KITTITAS COUNTY DEPARTMENT OF PUBLIC WORKS

MEMORANDUM

TO: All Staff
FROM: Public Works Plan Review Team
DATE: June 6, 2024
SUBJECT: BL-24-00009 Trust for Public Lands

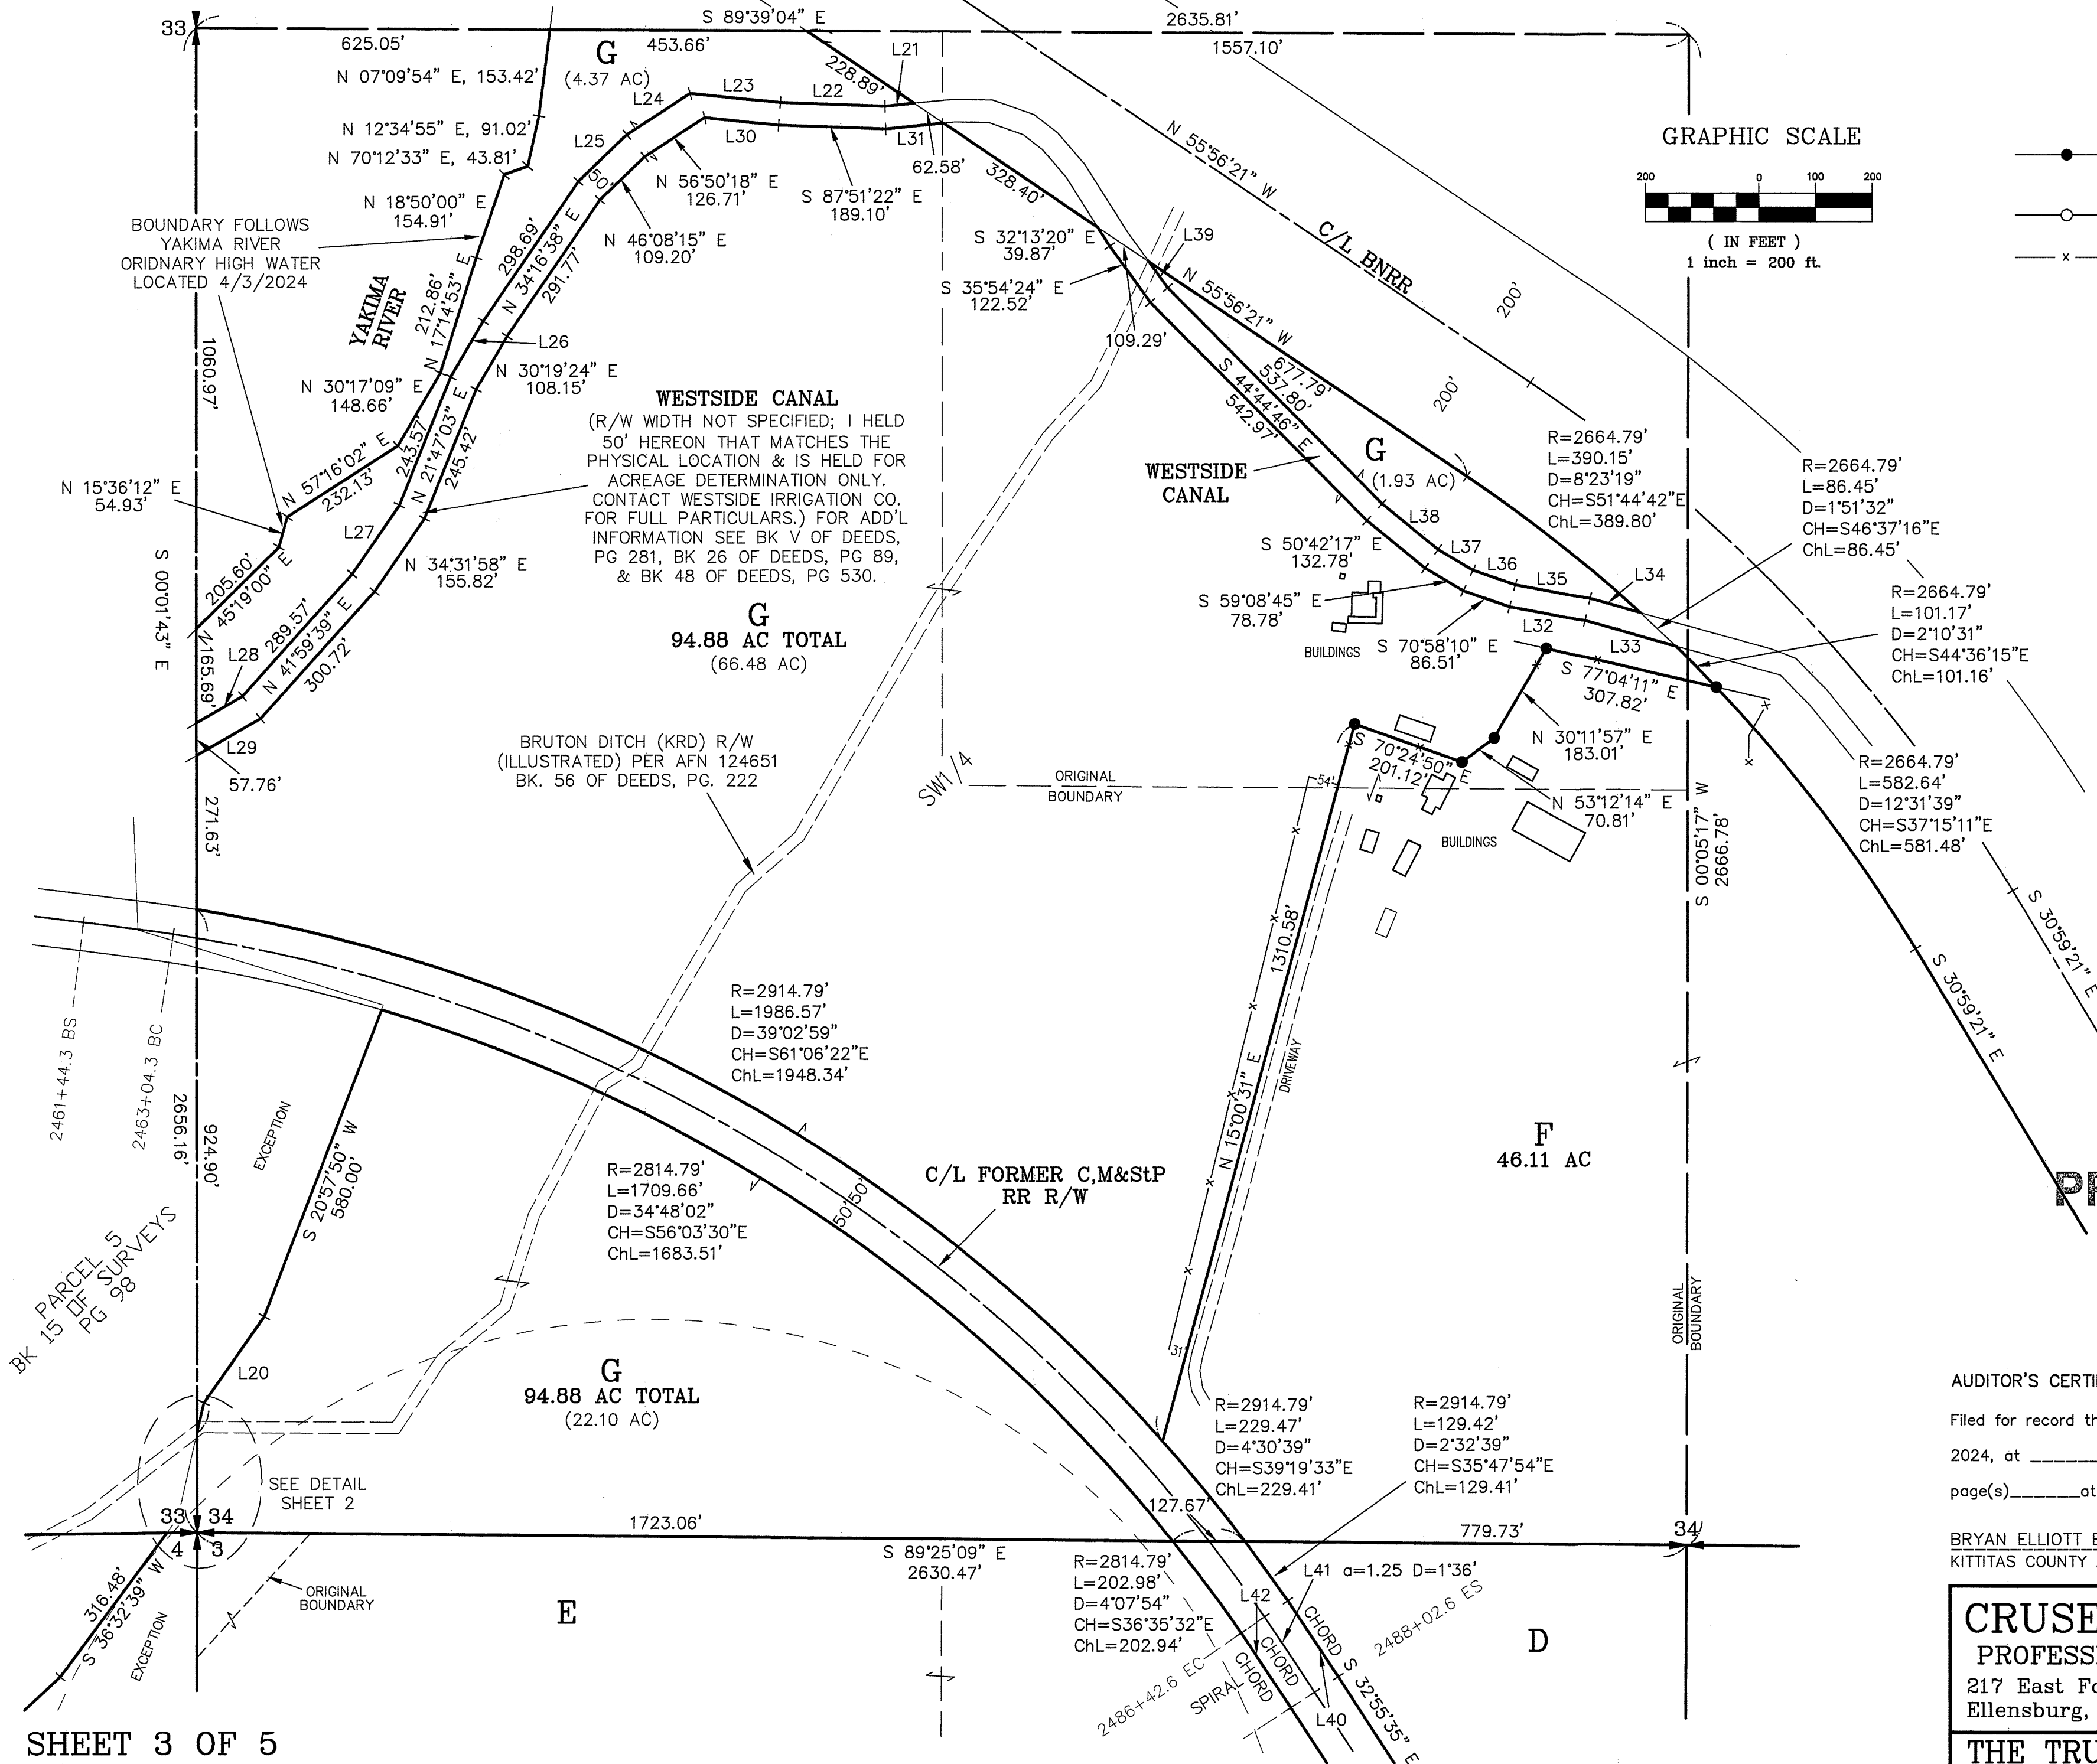
SURVEY	<p>As the application does not contain a survey map, comments are reserved until final. (KAH)</p> <p>UPDATE 08/14/2024</p> <ol style="list-style-type: none"> 1. The West boundary of Parcel G, N of John Wayne Trail is shown as 220.96', rather than the distance per closure report of 271.63'. Additionally there is a "tick" or "crowsfoot" here that appears to be incorrect. 2. The SW boundary of Parcel F has a type in the Chord Length (289.41 vs 229.41). 3. For the Westside canal, please reference the document(s) that do not show the width of the R/W. 4. Please confirm that the building located near the E edge of Parcel G meets 25' front yard setback from proposed property line? 5. Where spirals are shown, sufficient information to recreate the spiral at centerline will need to be provided. In instances where BS,BC,EC, and ES can be used to determine spiral length, the only thing that would need to be included would be the spiral rate of change ('a' value). For offsets to c/l spiral (edge of R/W), nothing additionally is needed. 6. At a minimum, the new division lines will need to be staked in the field and corners shown on the face of the map. Where the new property corner is coincident with a missing section corner, a survey marker stamped in accordance with the Manual of Survey instructions shall be set. 7. The Original Parcel Descriptions do not match the title report. While referencing a document of record is acceptable, this attempt goes so far as to essentially create a new legal description. Legal descriptions should be a direct reference to a document of record or written out in full. Whichever option is utilized must match the title report. (JT)
